**Application No:** 21/00184/DISC

**Proposal:** Discharge of condition 11 (surface water drainage scheme) of 16/02446/F

**Location:** Heyford Park, Camp Road, Upper Heyford, Bicester

## **Local Lead Flood Authority**

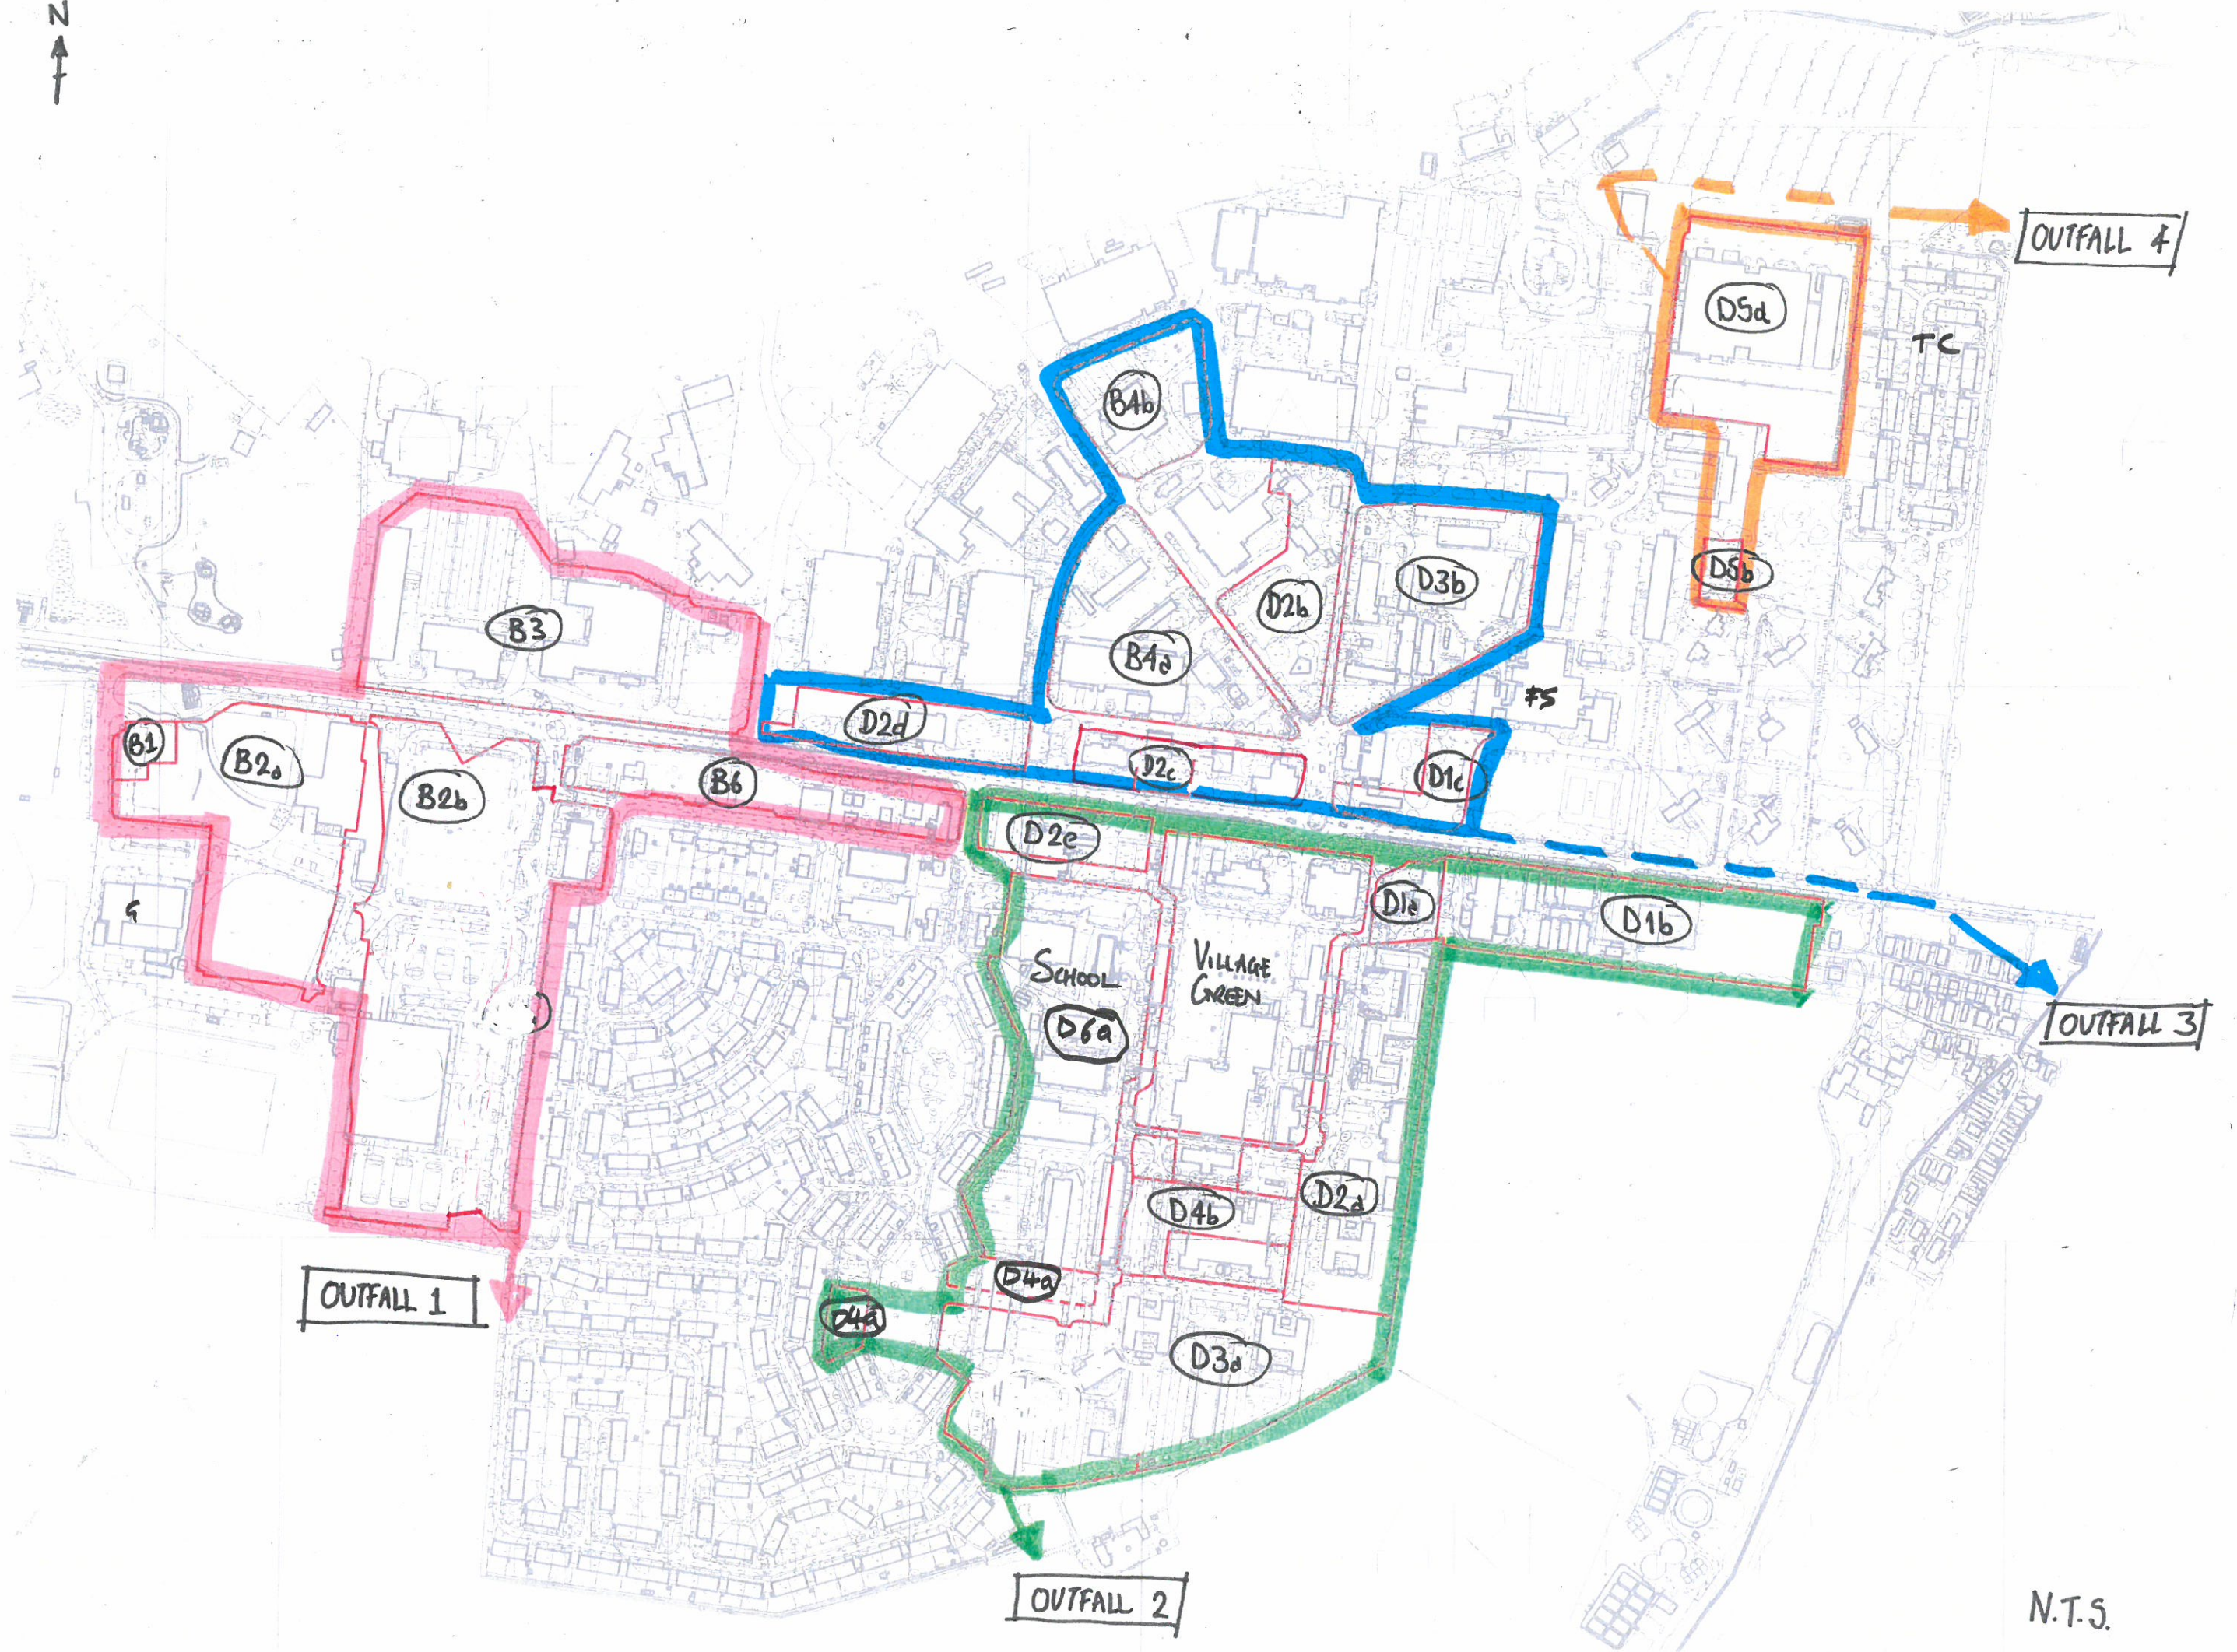
For the southern attenuation basin, the TWL during the 100y+30% event is 121.514mAOD with the GL of 121.520mAOD there is not the 300mm min freeboard provided. This is therefore likely to flood during the 40%cc event.

The northern attenuation basin TWL during the 100y+30% event is 121.514mAOD with the GL of 123.090, there is sufficient freeboard and is likely to be ok during the +40%cc event but needs checking.

- 1.007 – 0.091m<sup>3</sup>
- 5.000 – 2.955 m<sup>3</sup>
- 7.000 – 7.952 m<sup>3</sup>
- 11.000 – 3.392 m<sup>3</sup>
- 11.001 – 3.575 m<sup>3</sup>
- 16.000 – 0.173 m<sup>3</sup>
- 17.000 – 4.388 m<sup>3</sup>
- 23.000 – 1.577 m<sup>3</sup>
- 23.001 – 3.316 m<sup>3</sup>
- 4.000 – 107.392m<sup>3</sup> – This is substantial flooding but is offsite entering the system from the north. This flooding appears to be the result of 5000m<sup>2</sup> being directly entered into a DN225 pipe at once.

However, A flood exceedance plan is required to demonstrate that any excess flows in the event of a blockage to the system will be managed safely throughout the site.

Not all the pipe references on the plan match the calcs.
